Current Zoning: N1-A and R-8MF(CD)
Proposed Zoning: R-8MF(CD) and R-8MF(CD) SPA

The petition proposes to rezone one parcel to add an additional 4 townhome buildings for a total of 20 additional townhome units to the project and 116 units total for the site. This rezoning plan was previously approved under rezoning petition 2020-099.

**STAFF
RECOMMENDATION**

Staff recommends approval of this petition.

Rezoning Plan
Petition # 2022-205

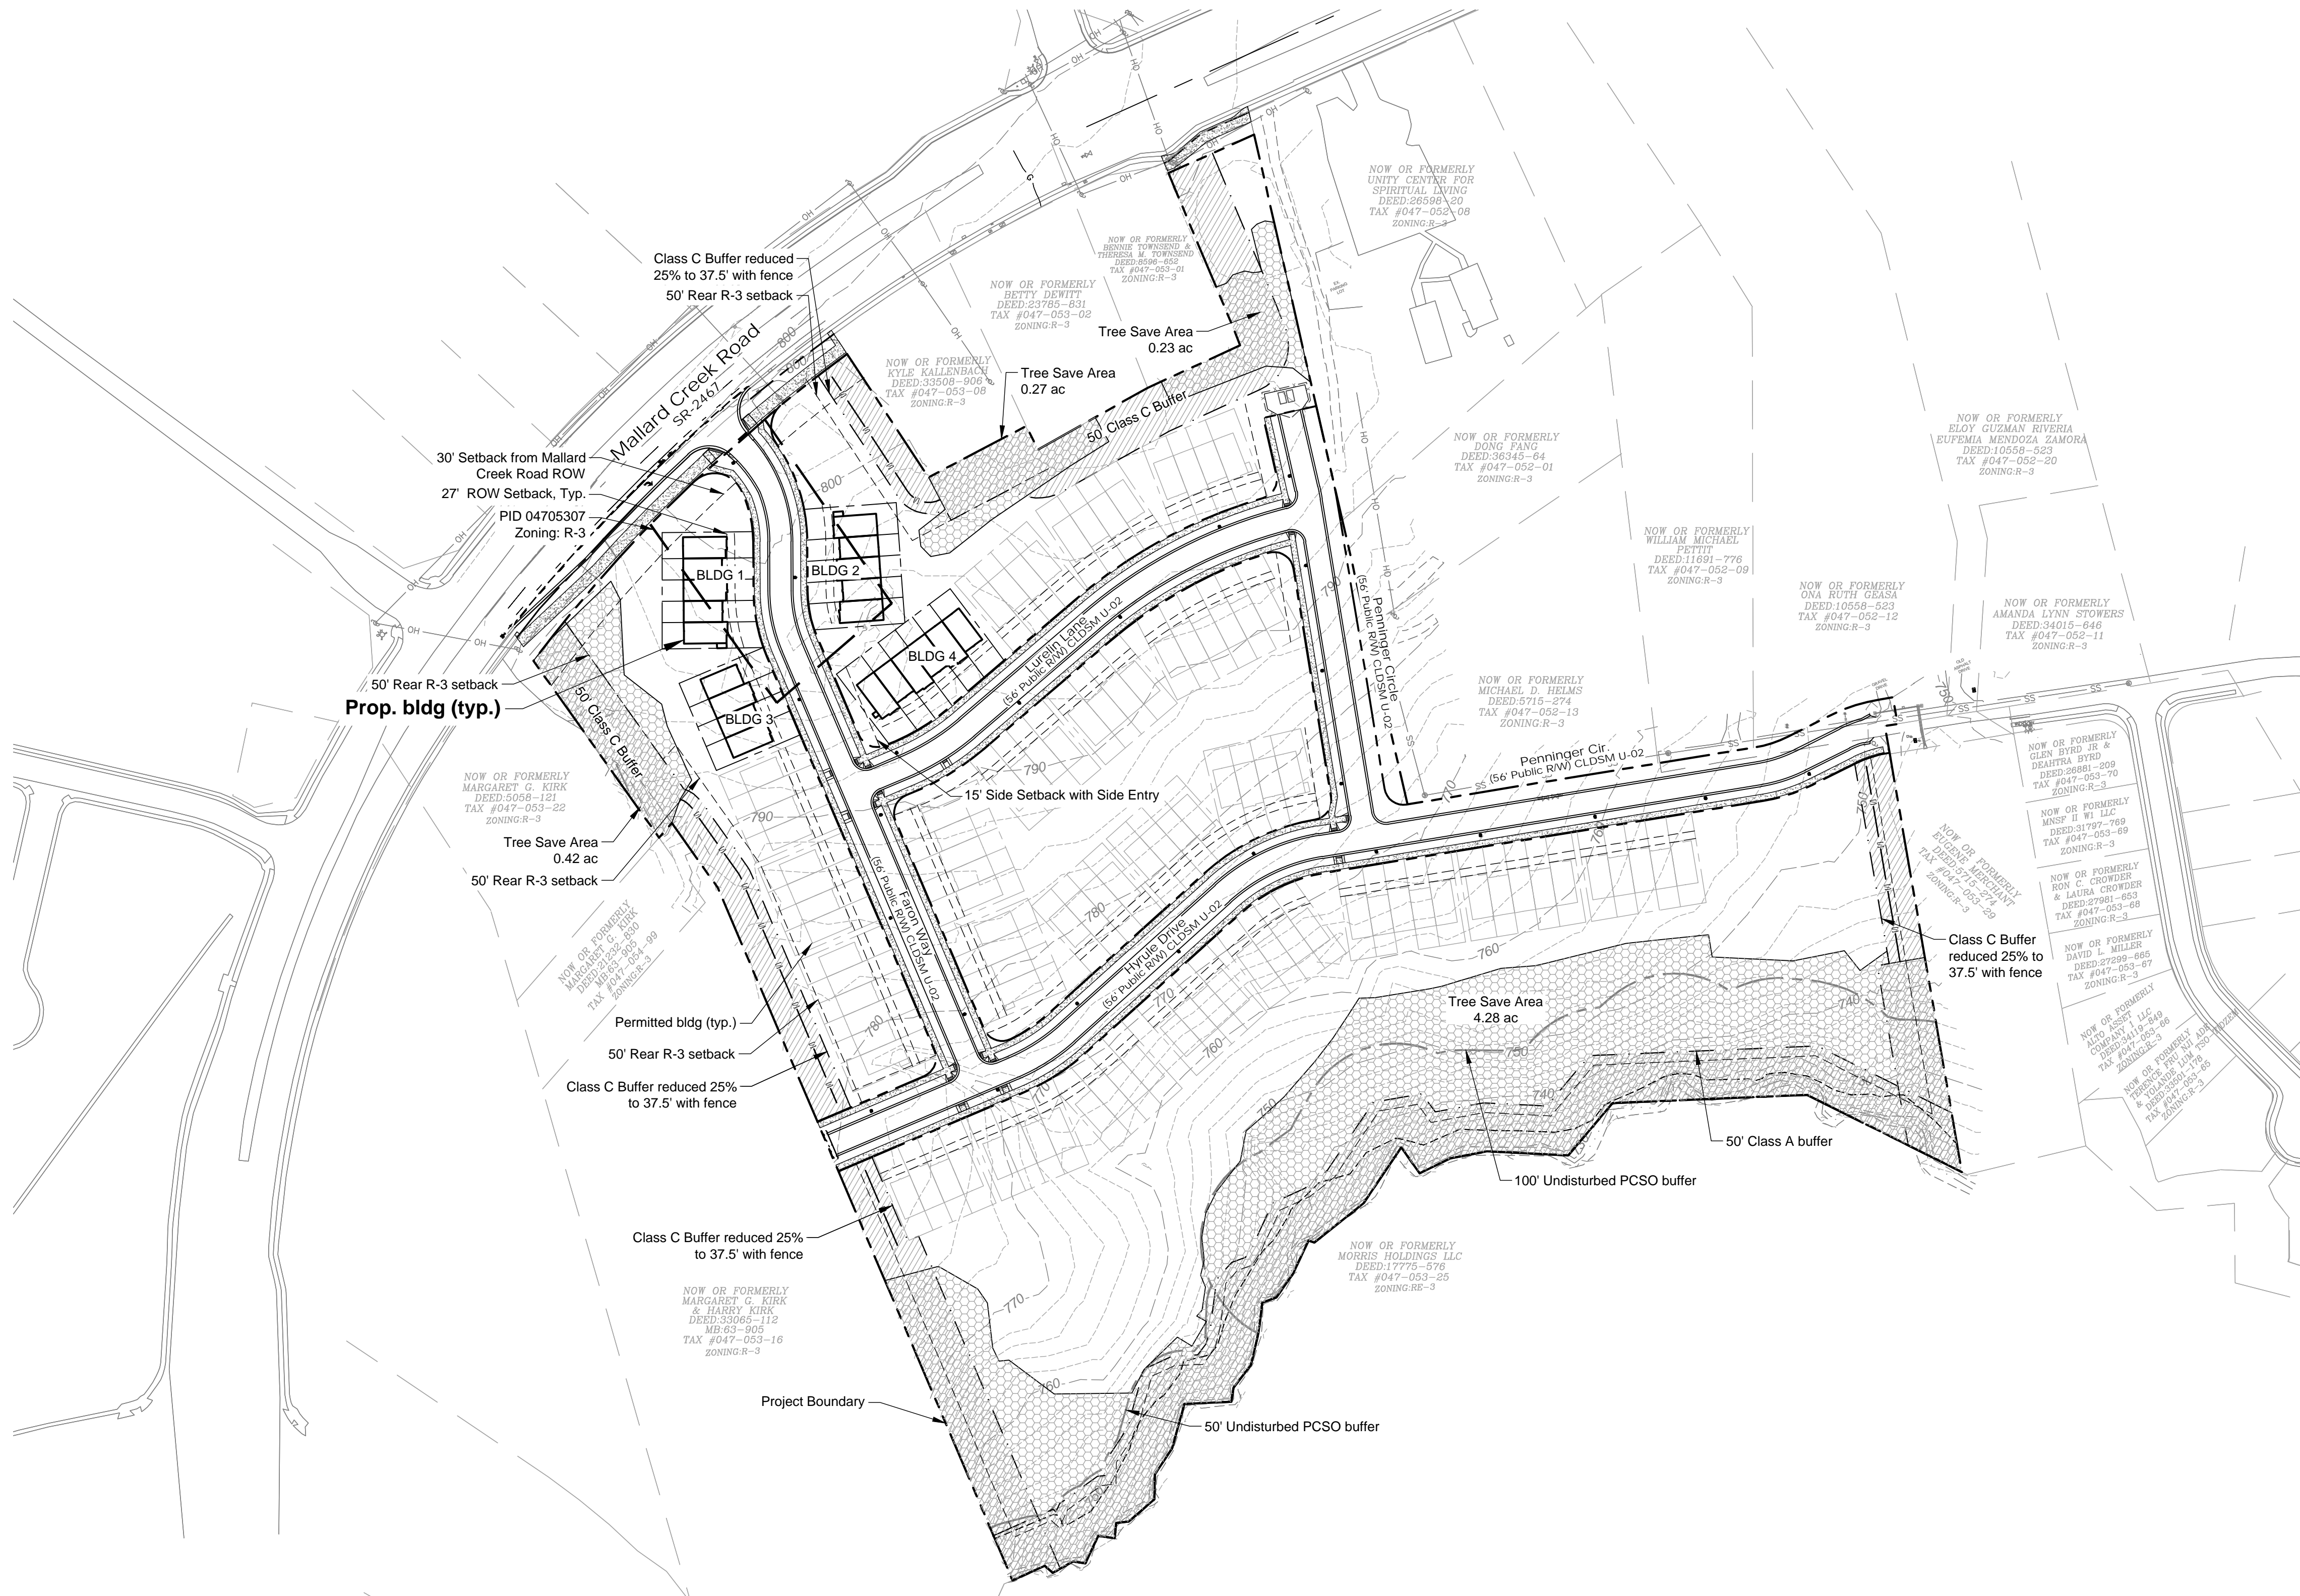
1. ~~Label and dimension the curb and gutter from the centerline for each road on the site plan.~~ Addressed
2. ~~Revise site plan and conditional note(s) to commit to dedicate 50 feet of right of way from the road centerline. The site plan shall label and dimension the right of way from the road centerline.~~ Addressed

3. ~~Add a conditional note specifying "A Right of Way Encroachment Agreement is required for the installation of any non-standard item(s) (irrigation systems, decorative concrete pavement, brick pavers, etc.) within a proposed/existing City maintained street right of way by a private individual, group, business, or homeowner's/business association. An encroachment agreement must be approved by CDOT prior to construction/installation. Contact CDOT for additional information concerning cost, submittal, and liability insurance coverage requirements."~~ Addressed

4. ~~Add a conditional note specifying "The petitioner needs to complete and submit the Right of way Abandonment Petition form to CDOT for review. The Right of Way Abandonment process is controlled by North Carolina General Statutes and is independent of this rezoning process."~~ Addressed

5. ~~Add conditional note specifying "All public roadway improvements will be subject to the standards and criteria of CDOT and NCDOT, as applicable, to the roadway improvements within their respective road system authority. It is understood that such improvements may be undertaken by the Petitioner on its own or in conjunction with other development or roadway projects taking place within the broad northeastern Mecklenburg area, by way of a private/public partnership effort or other public sector project support."~~ Addressed
